BL-09-00026 Maughan

RE: Maughan Boundary Line Adjustment, BL-09-00026

Parcel Numbers: 16-19-29000-0003 (955777) 12.14 AC
16-1 9-29000-0004 (955778) 16.70 AC

TO: Jeff Watson, Community Development Services
FROM: Christina Wollman, Planner II *W*
DATE: February 2, 2010
SUBJECT: Maughan BL-09-00026

WAOR 67571 - Maughan et.al. LLC  
Access Road

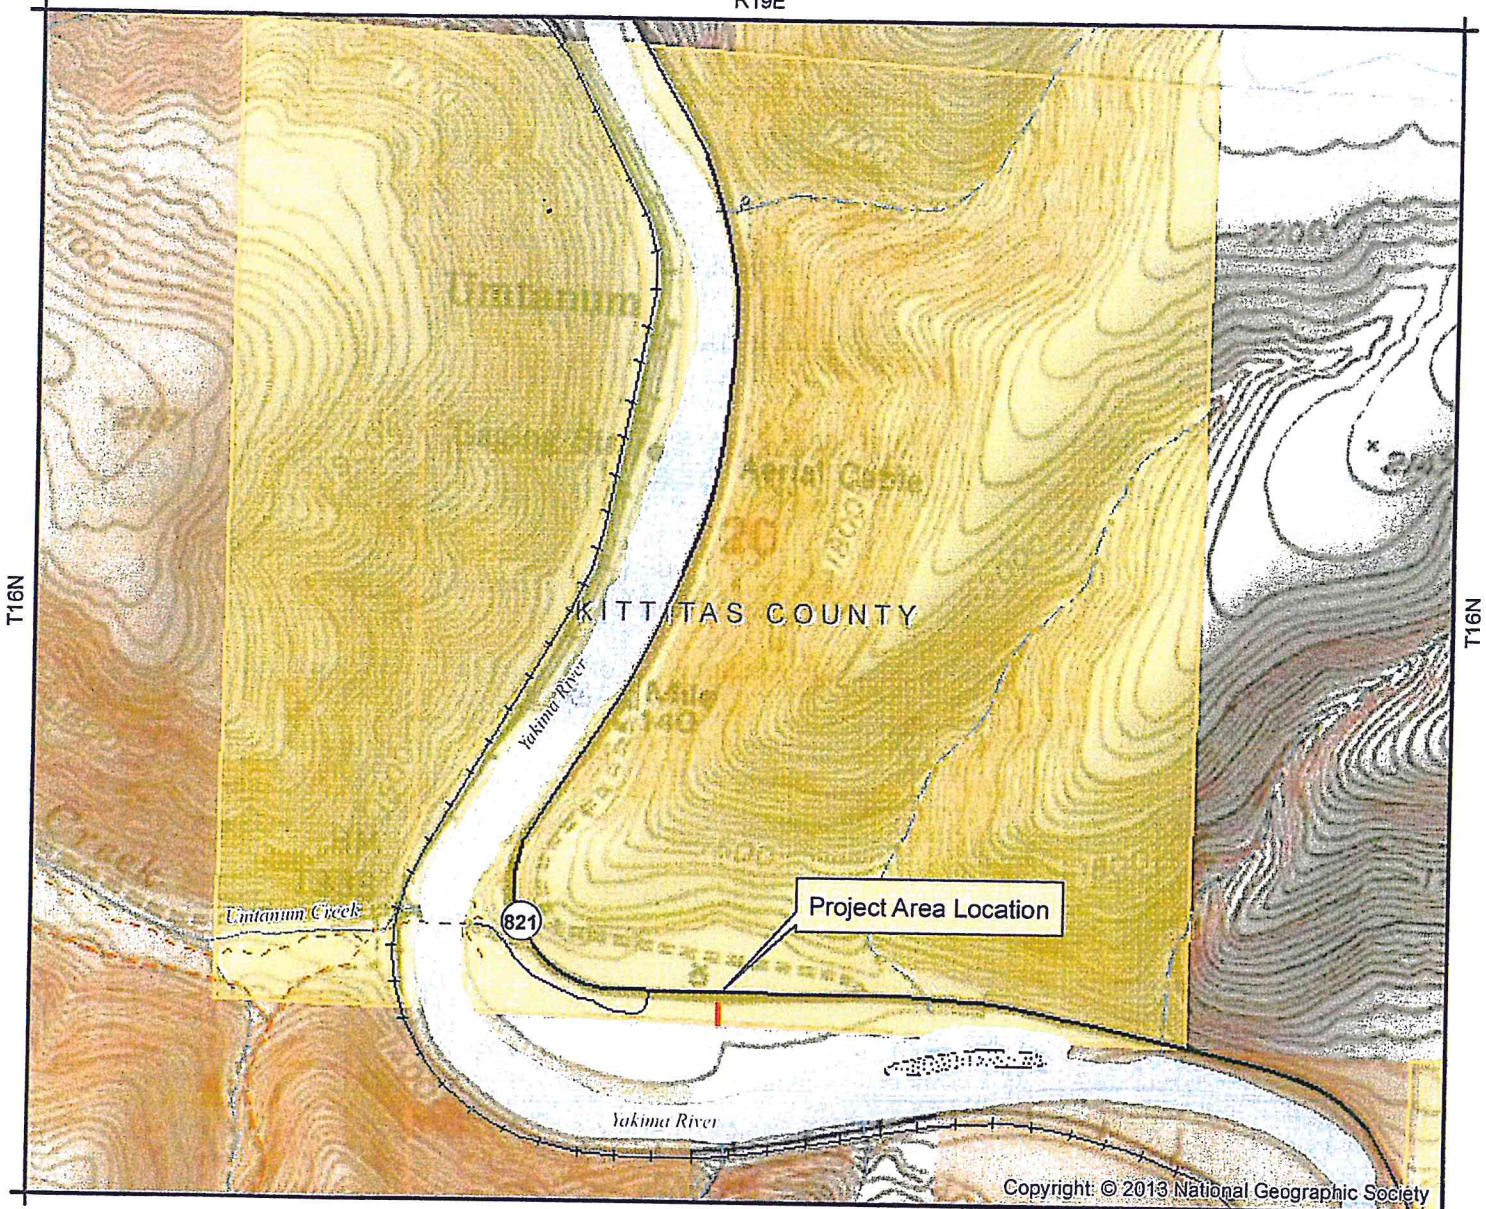
1. The access to SR 821 appears to cross over land under different ownership. Evidence of legal access for both lots shall be presented to Public Works prior to final approval.
2. Please refer to the attached Kittitas County Public Works Memo, and the Washington State Department of Transportation comment letter for information regarding additional requirements.
